WELWYN HATFIELD COUNCIL – DEVELOPMENT CONTROL
DELEGATED REPORT

APPLICATION No:	S6/2010/0457/FP
------------------------	------------------------

The proposed development would involve the erection of a gable sided, detached garage. The proposal would approximately measure 15m in width by 6.8m in depth with a ridged roof to a height of 6.1. The proposal would be adjacent to Wilkins Green Lane and have two gable dormers facing into the application plot. These dormers would approximately measure 1.1m in width by 2.1m in height.

Great Nast Hyde House		No. 6103/107	Rev. A
PROPOSED - Garage			
Scale 1:100 @ A3 Size	Date May 11, 2009	Drawn DB

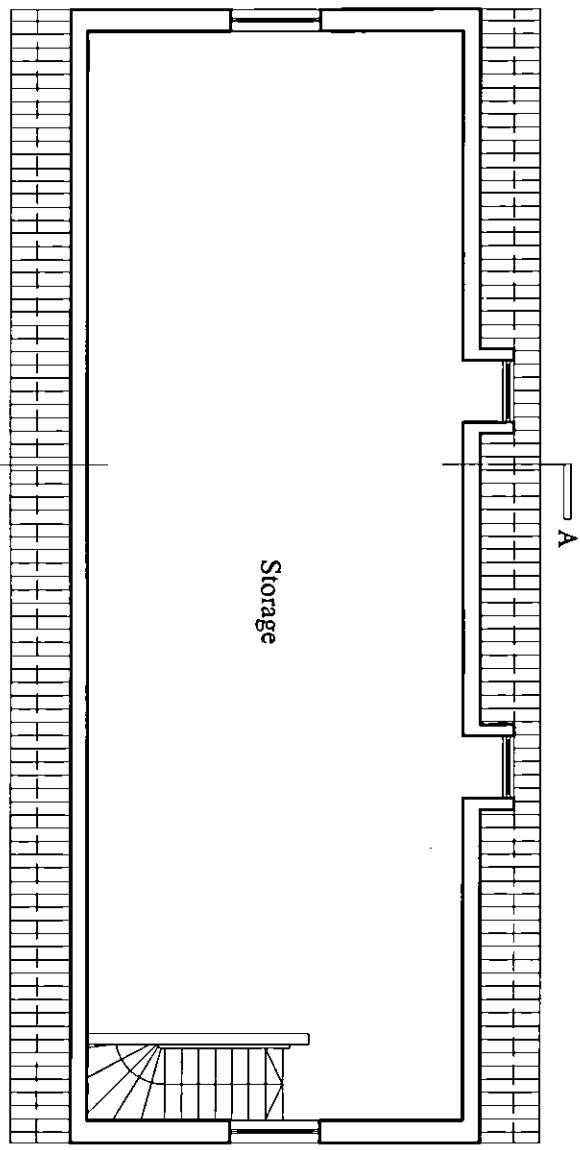
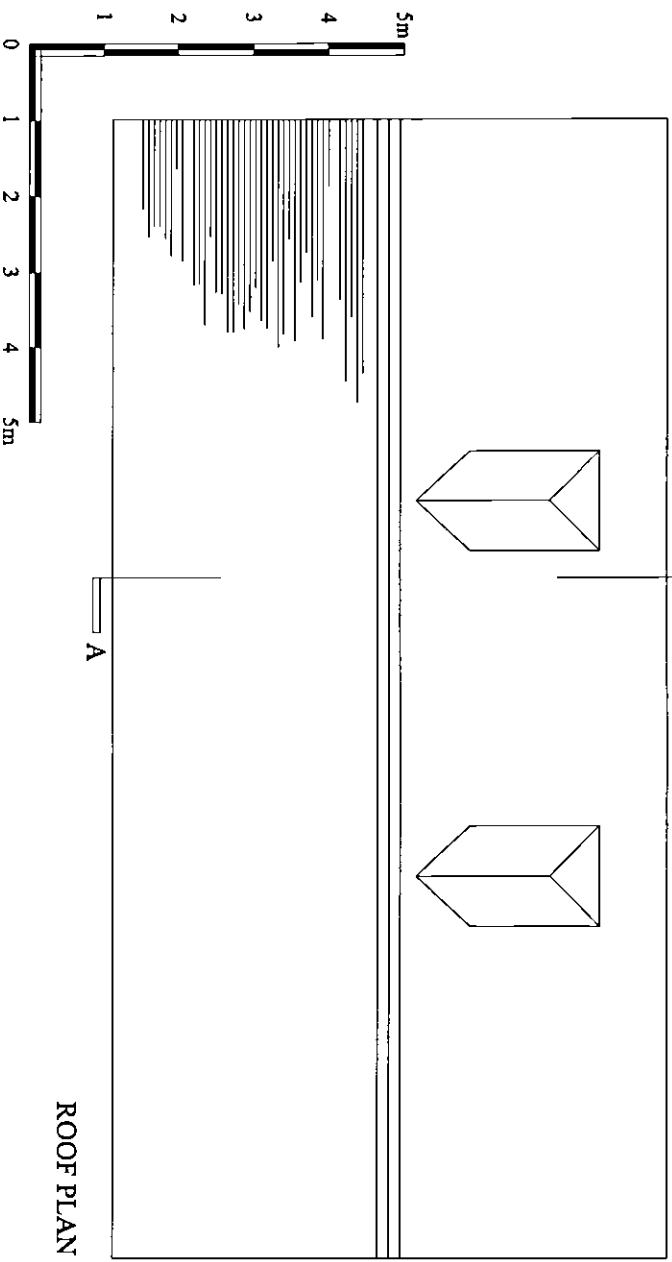
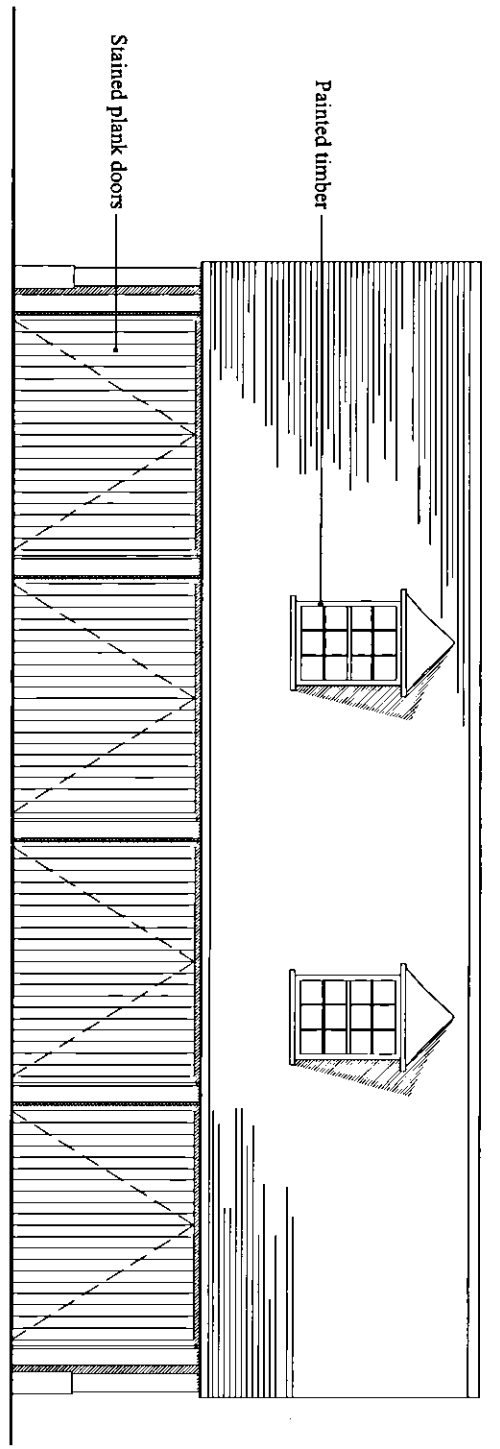
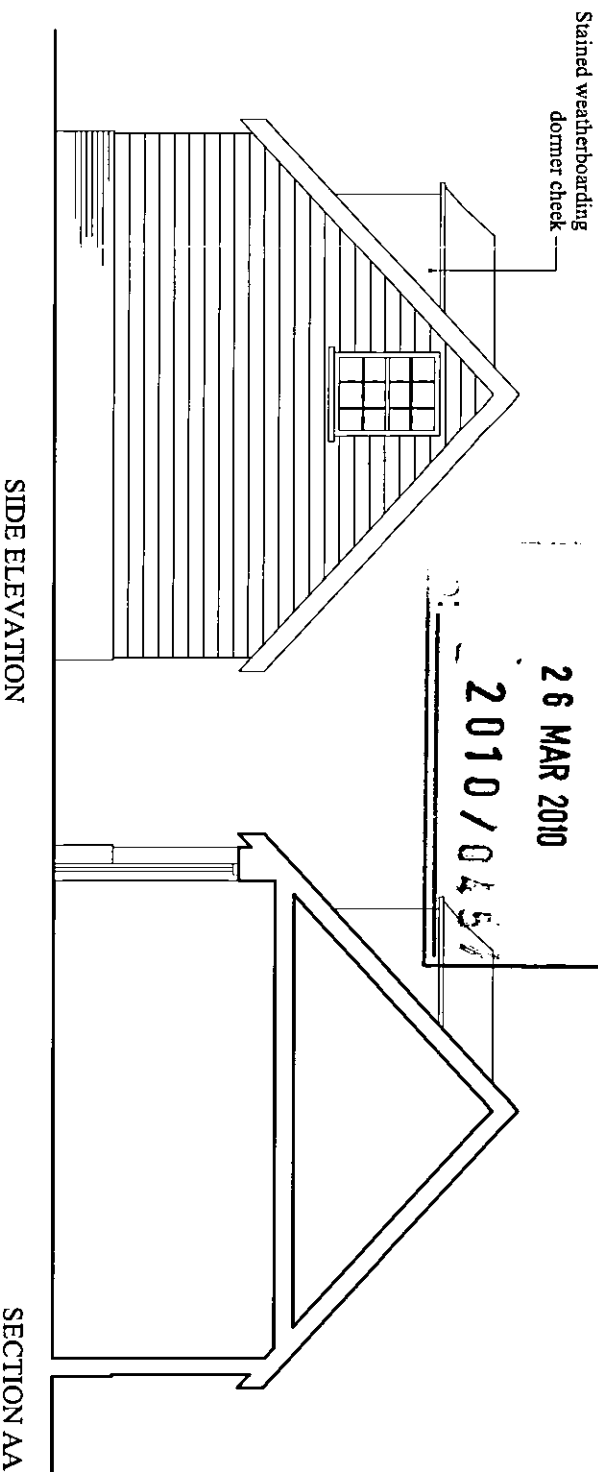
Although large the proposed garage would have good proportions and dormer windows that would be an appropriate size and appearance for the roof slope. When viewed in isolation the proposal would be an attractive building and would meet the high design requirement of Policy D1 of the Welwyn Hatfield District Plan 2005.

The previously approved scheme would have been a smaller building, approximately 3.9m less in width, 2m less in depth and 2.25m less in height. As a result it would have had a very single storey appearance with a low cat-slide roof. The proposed garage would appear two-storey and would be a large building. Although when

compared to the main dwelling the proposal would not appear excessive, the main house is a very substantial building. The proposed garage would have a footprint of roughly 102sq.m. The differences between the proposal and previous approval in height, bulk and massing are considered to be noticeable and would mean that the proposed garage would have larger and more dominant appearance.

The proposed garage would still be a relatively large building measuring 15m in width by 6.1m in height the extent of this addition would be clearly noticeable from Wilkins Green Lane. It has been acknowledged that the design has improved from the refused application under reference S6/2008/1158/FP, however, the reductions that have been made would not sufficient overcome the impact upon the openness of the Green Belt. Therefore, the development would fail to meet the requirements of PPG2 and Policy RA3 of the Welwyn Hatfield District Plan 2005.

Scale	Date	Drawn	No.	Rev.
1:200 @ A1 Size	Mar 2, 2010	DB	6103/105	A

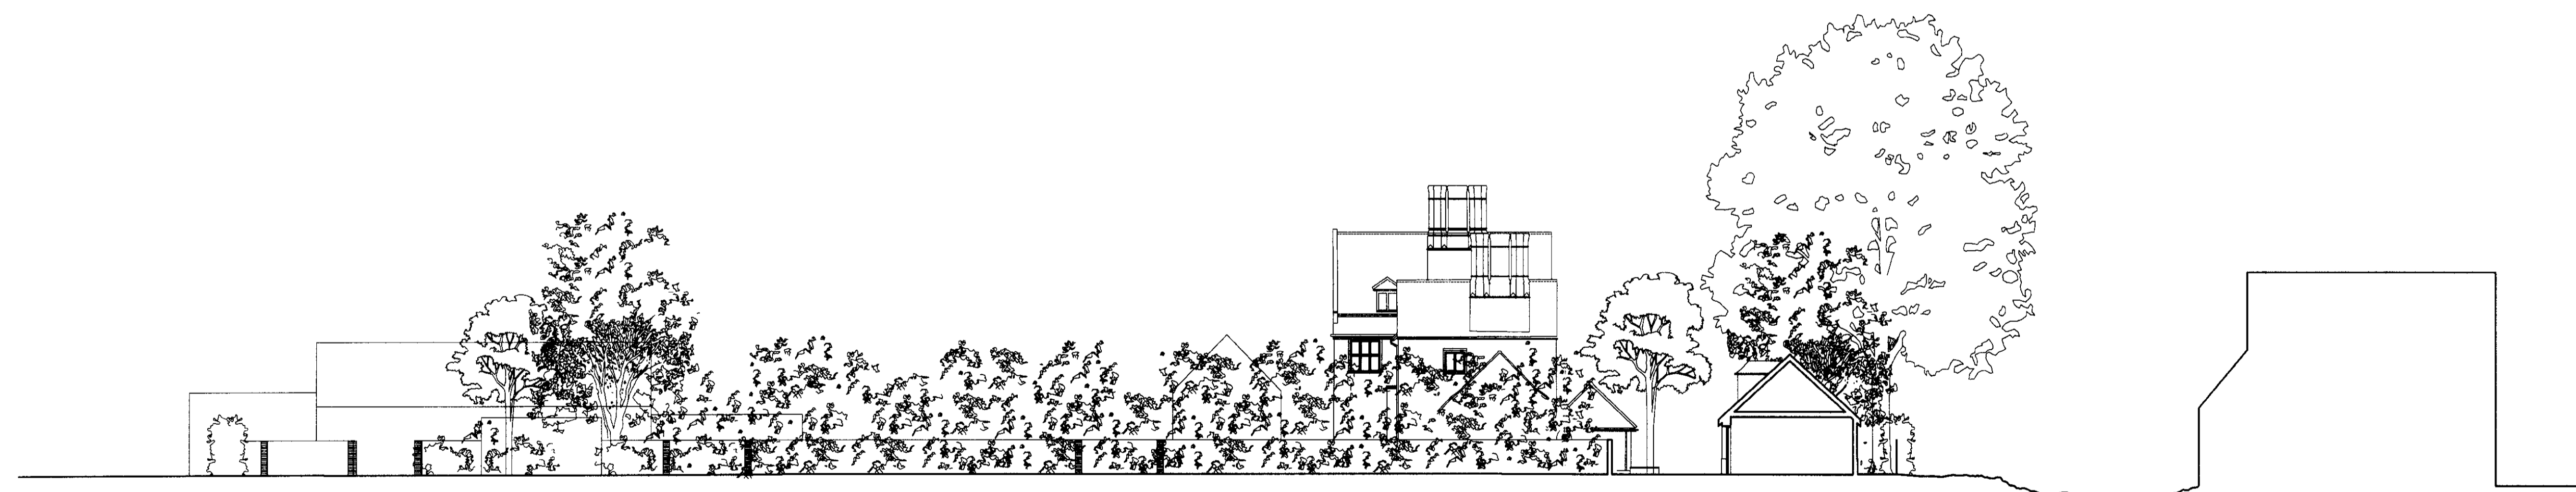
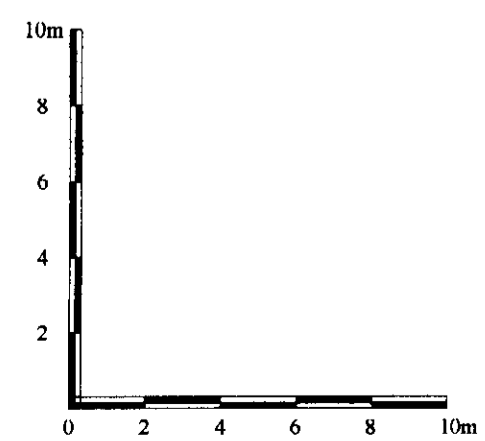
2. In terms of the siting to the proposed development, it would have an appropriate positioning in relation to the buildings on the other side of Wilkins Green Lane. However, being sited approximately 55m from the dwelling, and being proposed for use as a garage and storage area is not considered to be appropriate and reflective of the pattern of development in the locality. When compared to the

The proposed garage outbuilding would form a prominent addition that would spread development across the application site. This addition would be easily viewed from the surrounding area and have an adverse impact upon the open character of the Green Belt and therefore, the application has failed to meet the requirements of Policy RA3 and PPG2.
